THE ABLE MARINE ENERGY PARK DEVELOPMENT CONSENT ORDER

TR030001

Written Representation submitted on behalf of the Harbour Master, Humber

Unique Reference Number	URN [REDACTED]
Rule No.	8(1)(a), 10(1) and (2)
Document Ref.	WR01
Author	Harbour Master, Humber
Date	29 June 2012
Date of revision & version number	29 June 2012 (Revision 1.0)

Works Plan - Key Plan

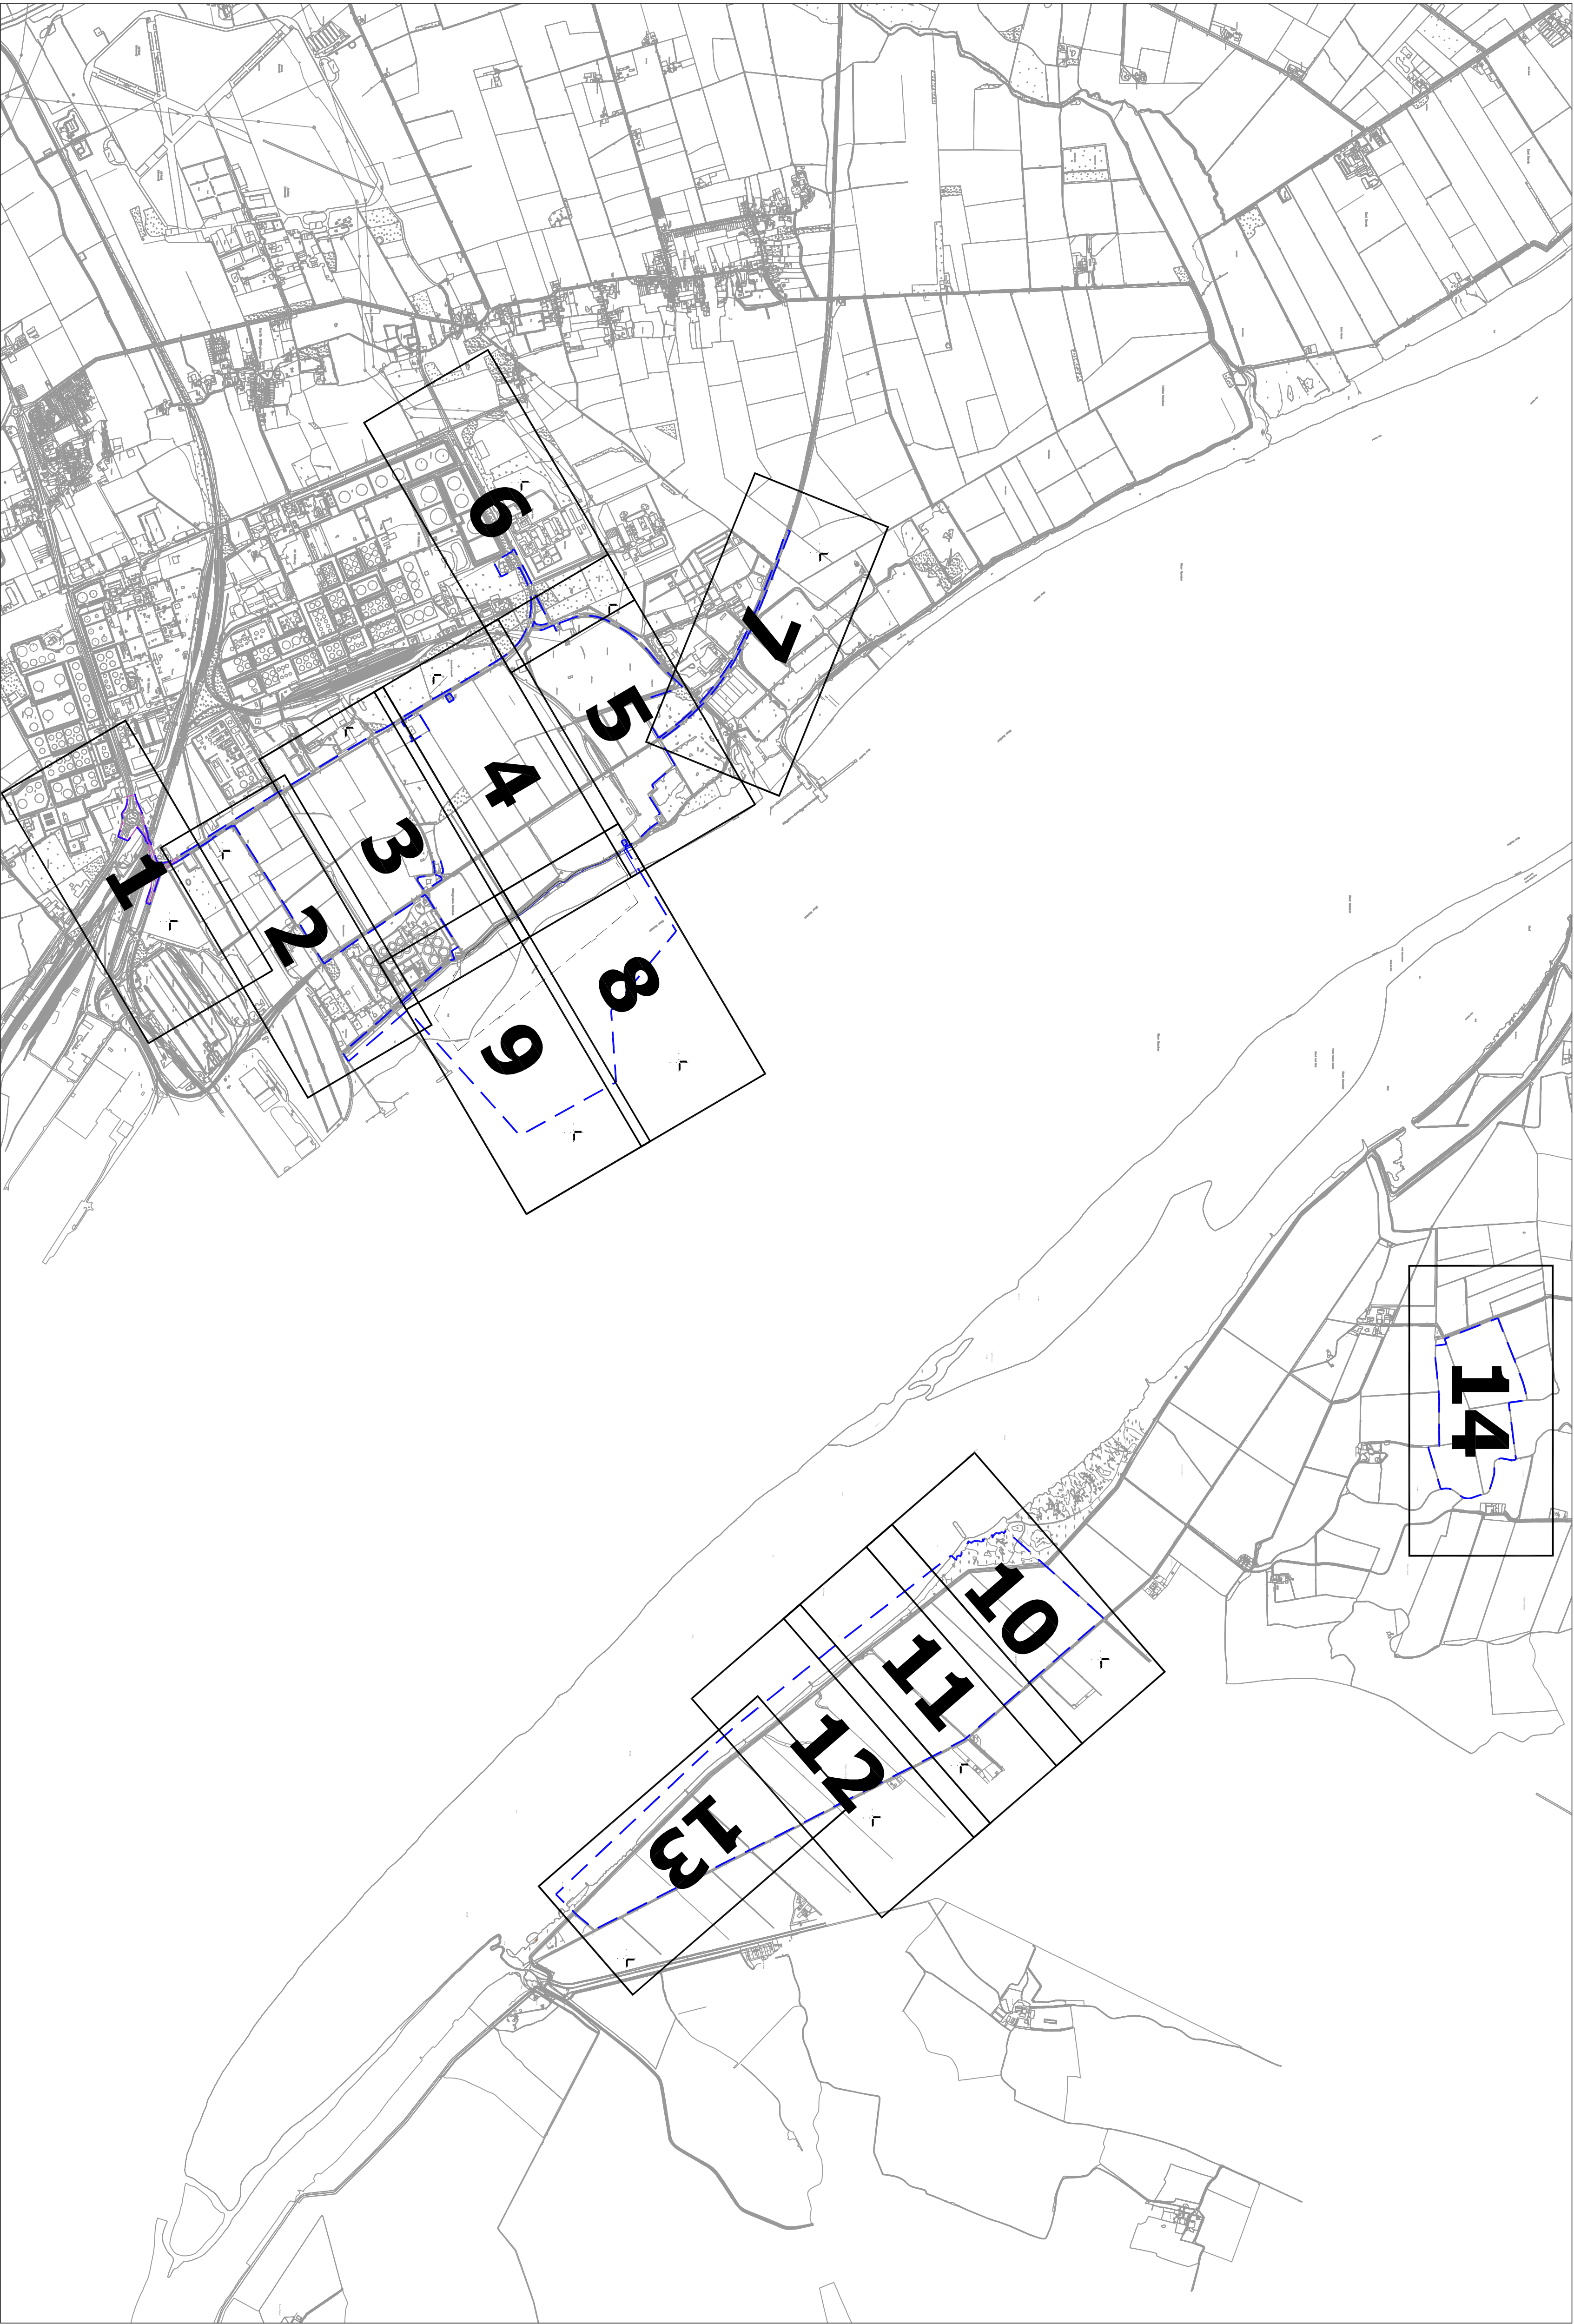
5. "the Order limits" are defined as limits "shown as such" on the works plan. It seems probable that the intended Order limits are the same as the limits of the development area shown on the works plan as a dashed blue line. However, none of the lines on the works plan is described as an Order limit. This needs to be corrected.

7. "the land plan" and "the works plan" are both expressed and defined in the singular. As there are several sheets of land plans and works plans, even if the defined term is singular the definition should be plural. **[Amendments 5 and 7]**

5. Article 2(1), in the definition of "the land plan", leave out the second "plan" and insert "plans".
6. Article 2(1), in the definition of "relevant planning authority", leave out "local" and insert "district planning".

7. Article 2(1), in the definition of "the works plan", leave out the second "plan" and insert "plans".
8. Article 12, after paragraph 1 insert—
 - "(2) The powers of paragraph (1)(a) may only be exercised by the Company or a transferee.
